# KITITAS COUNTY

### MEMORANDUM

**TO:** All Staff  
**FROM:** Public Works Plan Review Team  
**DATE:** December 15, 2025- UPDATE 1-13-26  
**SUBJECT:** SPF-25-00009 Mills

## LEGAL DESCRIPTION FOR ACCESS EASEMENT ACROSS LOT 5C FOR LOT 5D

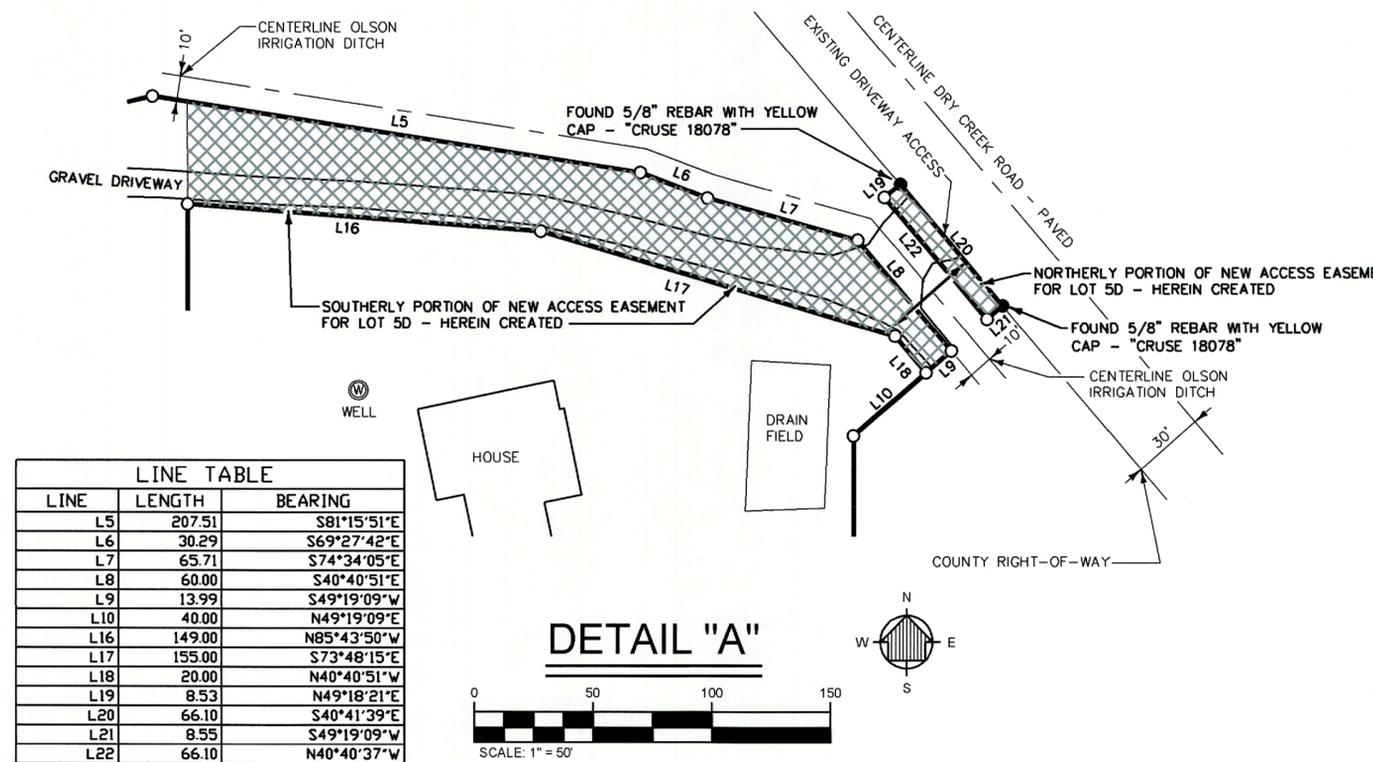
<b>ACCESS</b>	<ol style="list-style-type: none"> <li>1. An approved access permit shall be required from the Kittitas County Department of Public Works prior to creating any new driveway access or altering an existing access.</li> <li>2. KCC Title 12.04.07.060 requires a minimum 30' easement for a shared residential driveway recorded prior to final.</li> <li>3. Maintenance of driveway approaches shall be the responsibility of the owner whose property they serve. The County will not maintain accesses.</li> <li>4. Any further subdivision or lots to be served by proposed access may result in further access requirements. See Kittitas County Road Standards.</li> </ol> <p>In addition to the above-mentioned conditions, all applicable Kittitas County Road Standards apply to this proposal. Access is not guaranteed to any existing or created parcel on this application. (RC)  <b>Update 1/13/26</b>            Access Easement meets Public Works requirement for shared residential driveway.(RC)</p>
